**RE: TAMWORTH HOSPITAL REDEVELOPMENT (SSD 5204)**

I refer to correspondence received by Council from the Department of Planning and Infrastructure on 27 July 2012 regarding the proposed redevelopment of the Tamworth Hospital on land known as Lots 99 and 335 DP 753848, Lots 1 and 2 of DP 533835 and Lot 1 DP 712550, being 31 Dean Street, NORTH TAMWORTH.

Council staff have reviewed the documentation provided and now provide the following comments and recommended conditions of consent:

Figure 4. Proposed Catchments

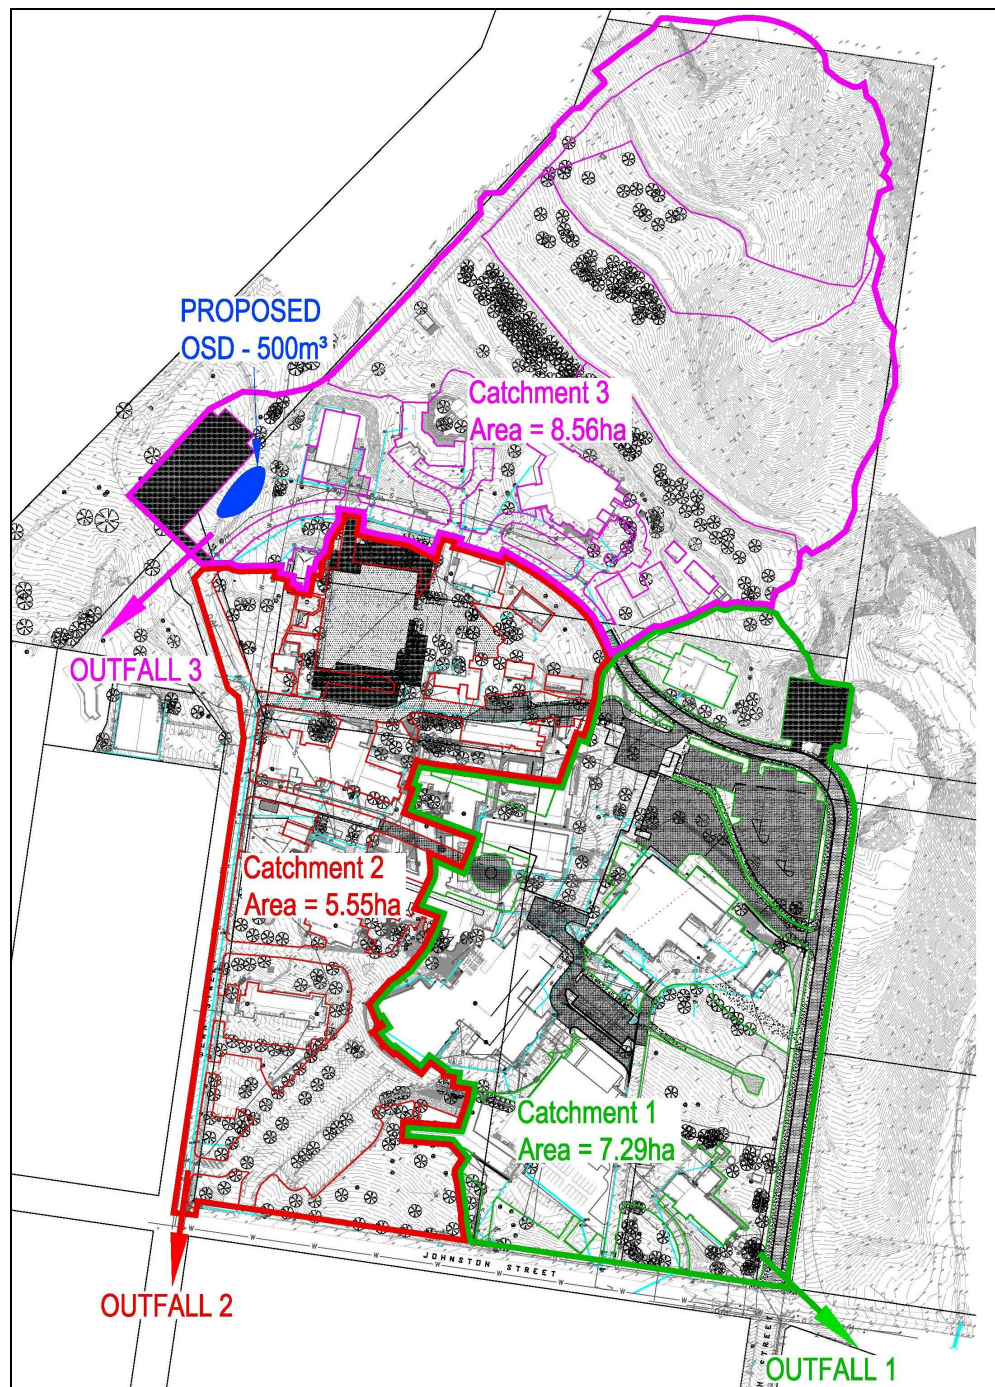
It is noted in the Stormwater Management Plan that 1 m<sup>3</sup>/s is proposed as the minor flow from catchment 2 (which discharges at the Johnston Street/Dean Street intersection), which exceeds the capacity of the existing system, and as such, on-site detention should be supplied to control the discharge to 0.6 m<sup>3</sup>/s for events up to and including the 1 in 10 year ARI event.

All stormwater flows of hardstand areas for peak flow events up to and including the 1 in 10 year ARI event shall be piped to Councils existing stormwater infrastructure at the north-eastern corner of the Dean and Johnston Street intersection. Onsite detention systems shall be provided such that the discharge for the peak flow in the 1 in 10 year ARI event does not exceed  $0.6\text{m}^3/\text{s}$ .
